CBP 9-2
CLAREMONT BUSINESS PARK-LOT 9-2
1405 SELIX GROVE
COLORADO SPRINGS, CO 80915
EL PASO COUNTY, COLORADO

DATE: JAN. 26, 2018
DRAWN BY: L. PETERSON
PROJ. MGR: Z. GRABTREE
SCALE: SEE PLAN
APPROVED BY:
JOB NO: 1065

Markup Summary

1 SITE PLAN  
SCALE: 1"=20'-0"

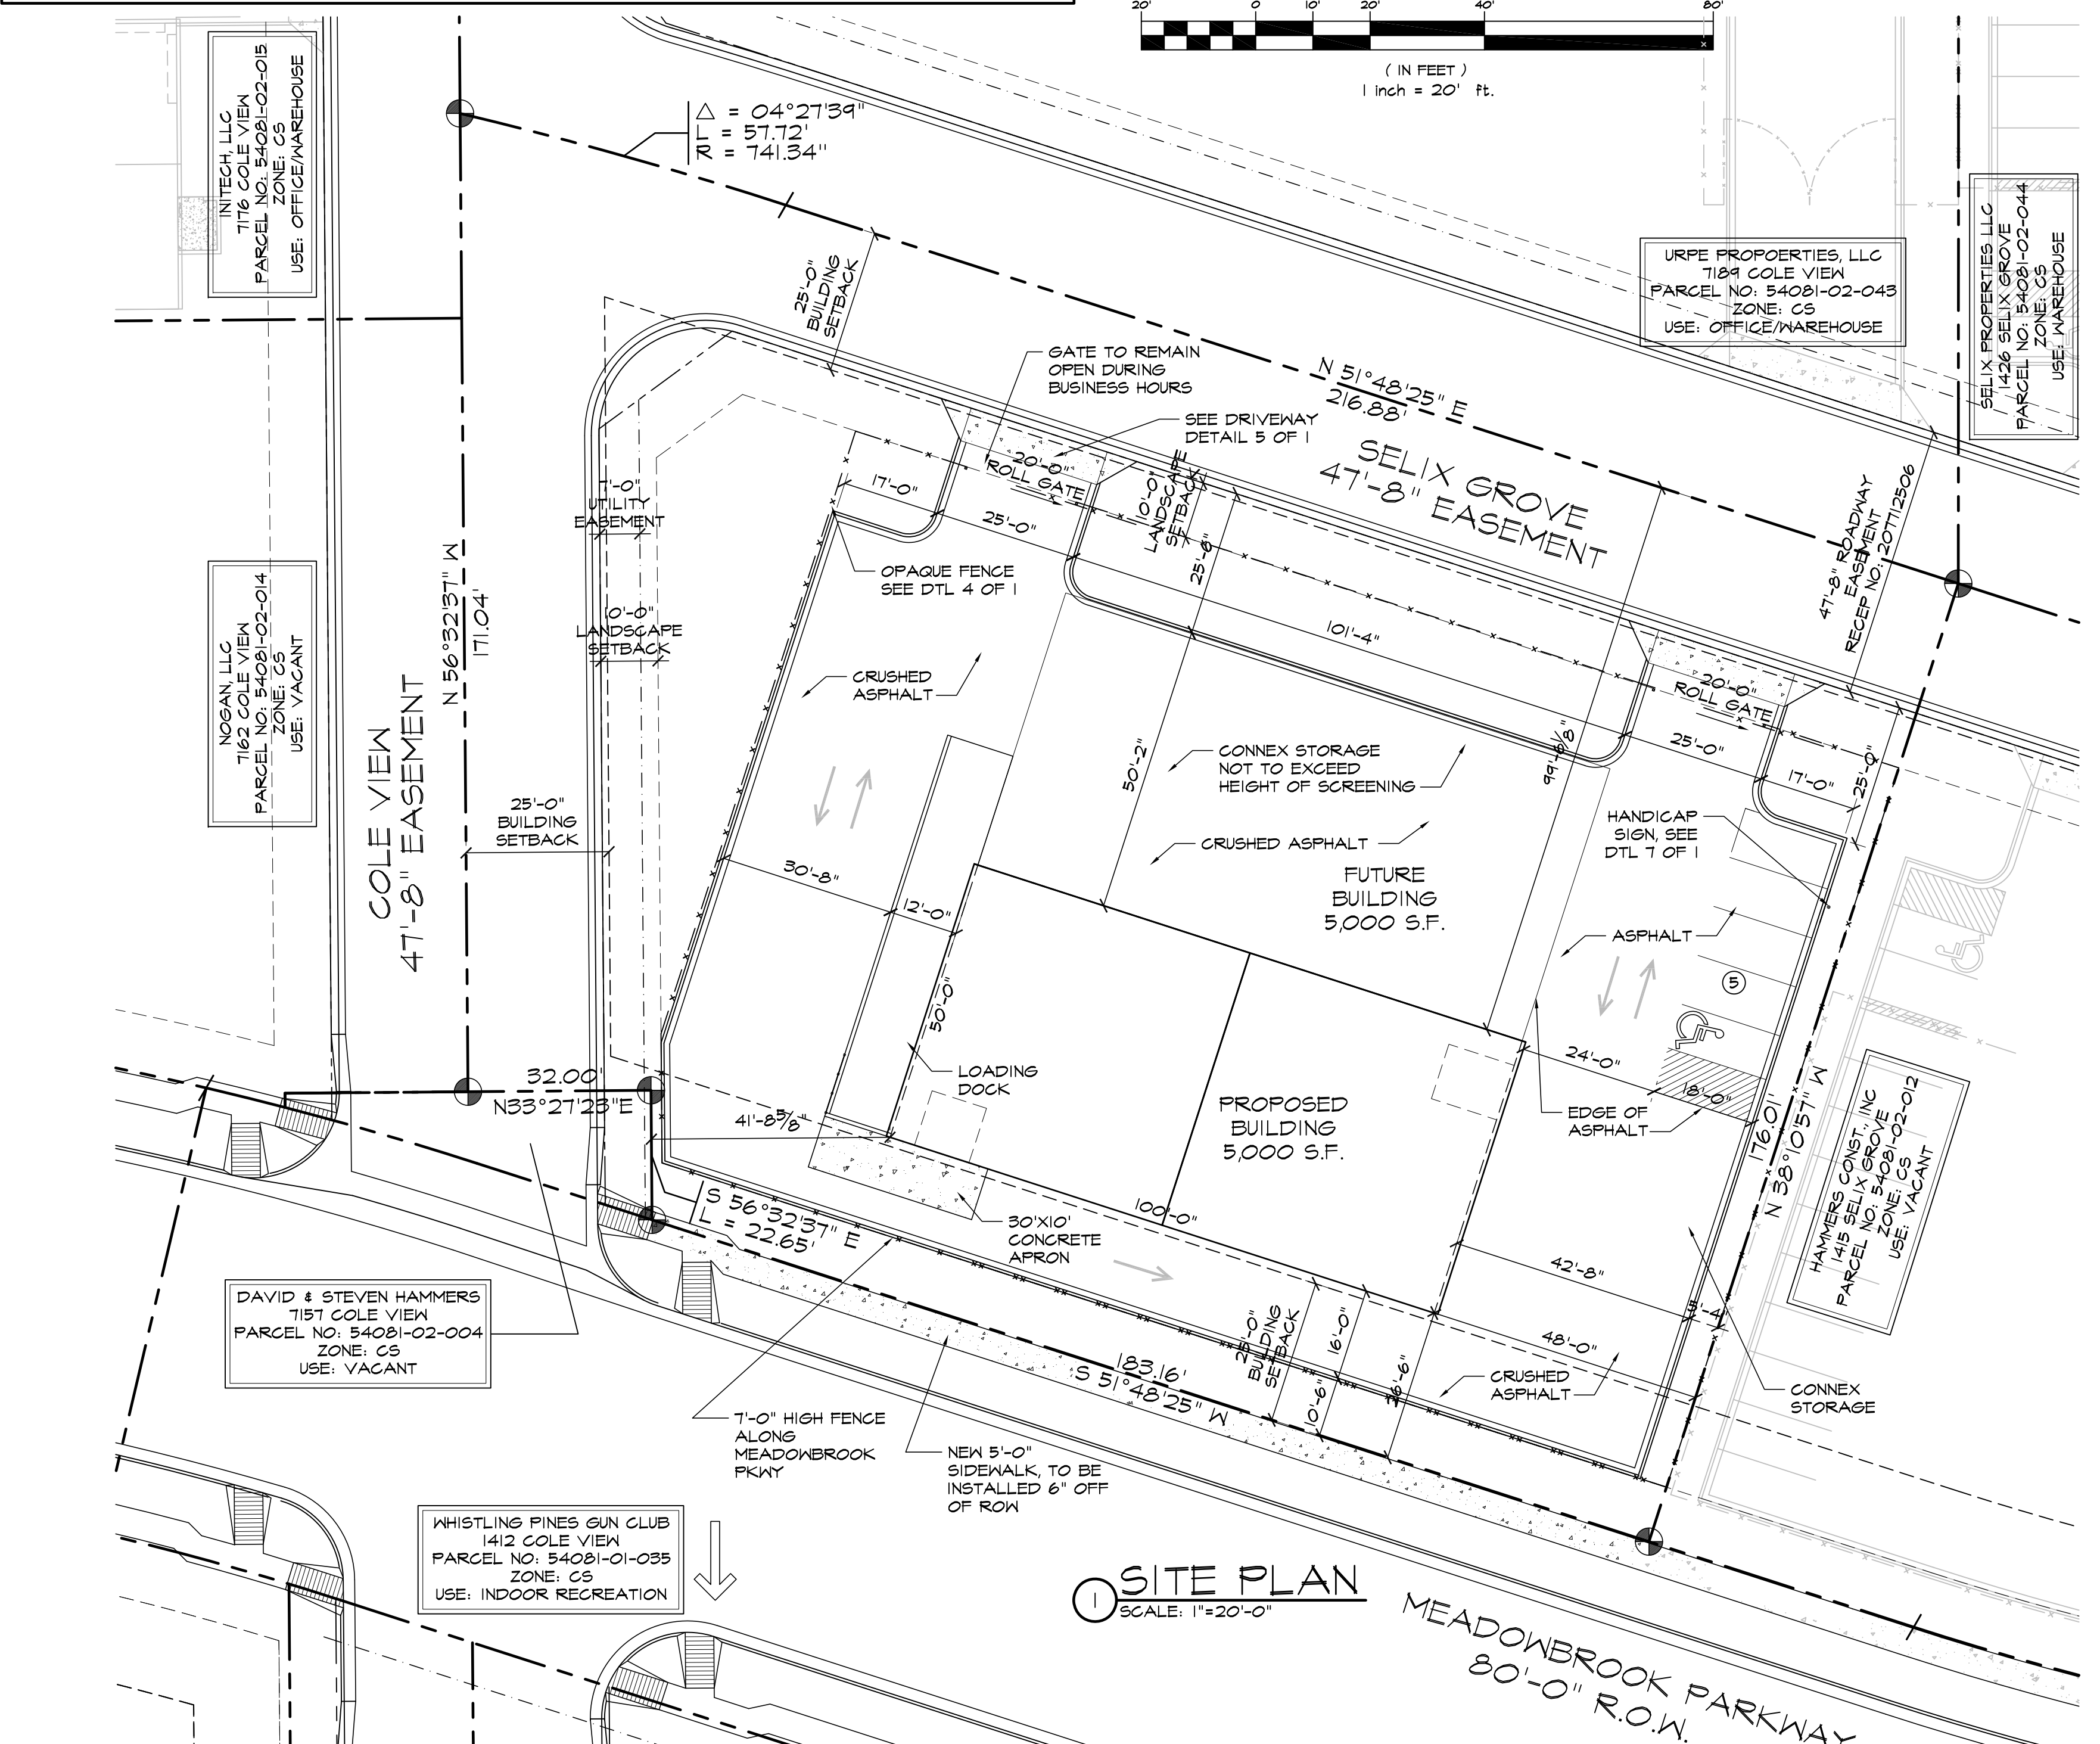
Outside storage not to exceed height of screening.

The future structure will require an additional 5 parking spaces, when the time comes.

Show where the outdoor storage will be located.

Outside storage will need to be 100% screened.
LDC 5.2.38

Provide a typical cross section or a dimension label noting a 6" offset between the ROW and edge of sidewalk.

Clarify where the demarcation line between
crushed asphalt and asphalt
